Consultation Response from: KC Environmental Health (Pollution & Noise Control)

2025/91531 land off, Leeds Road, Heckmondwike, WF16 9DB

**REVISED AND ADDITIONAL INFORMATION RECEIVED, AND REVISED DESCRIPTION:
Demolition of existing semi-detached houses and associated buildings, and construction of 49 dwellings, including associated access and other associated works**

**Responding Date:
9th April 2026**

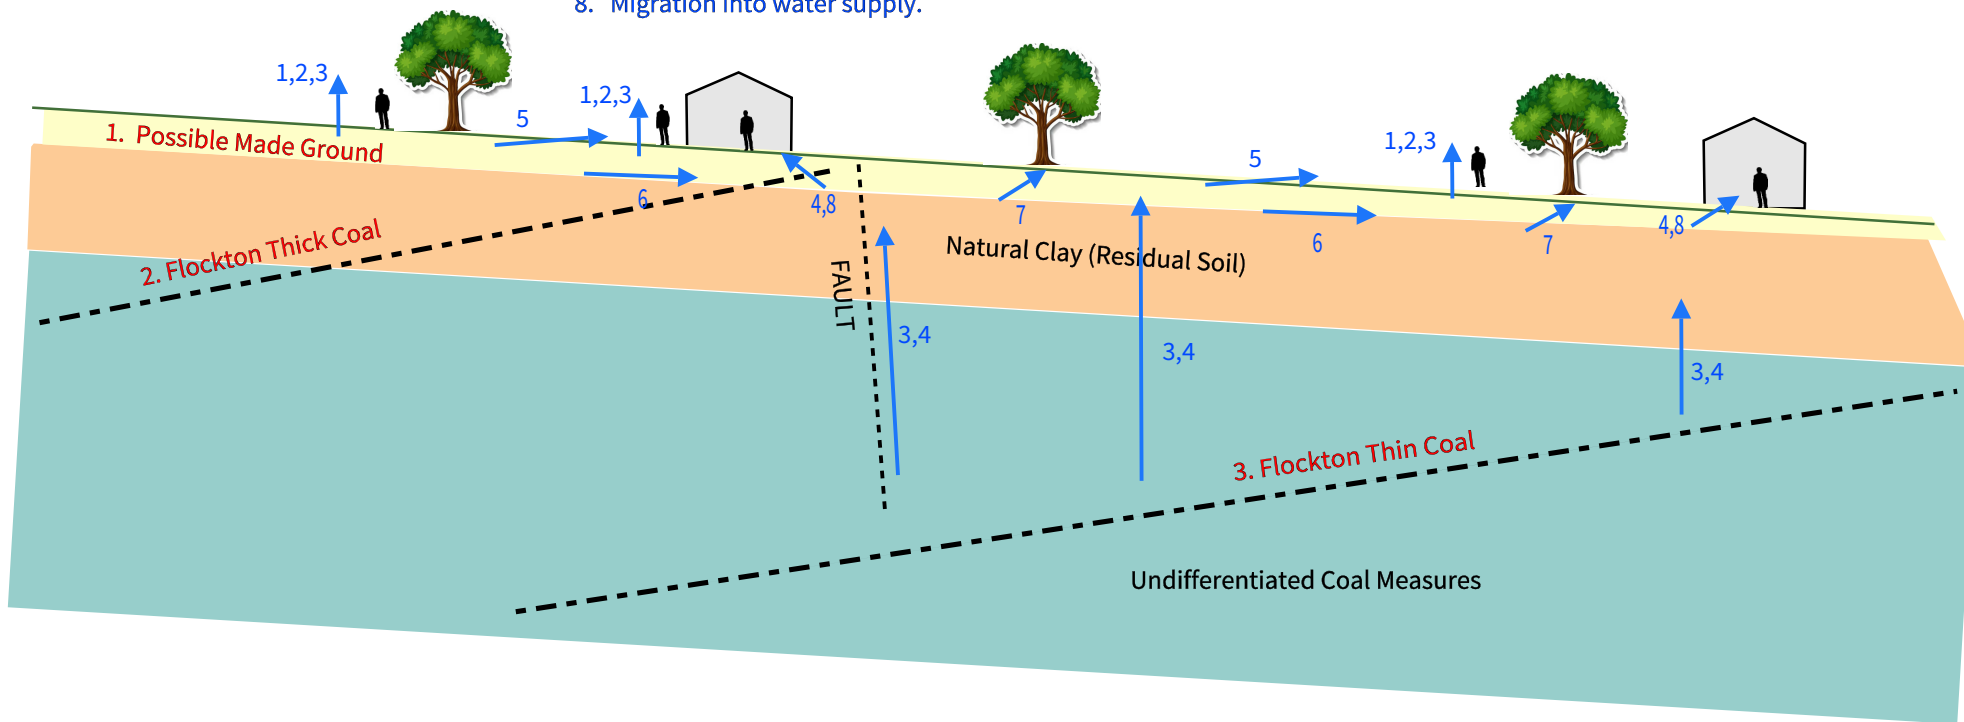
Whilst we accept the professional assessment of the gas data of the report author, we require an updated Phase 2 report answering all the points we have raised and a revised conceptual site model, any site characterisation differences must be clearly identified on a plan (e.g. CS1/CS2 and areas where coal may need to be removed/covered).
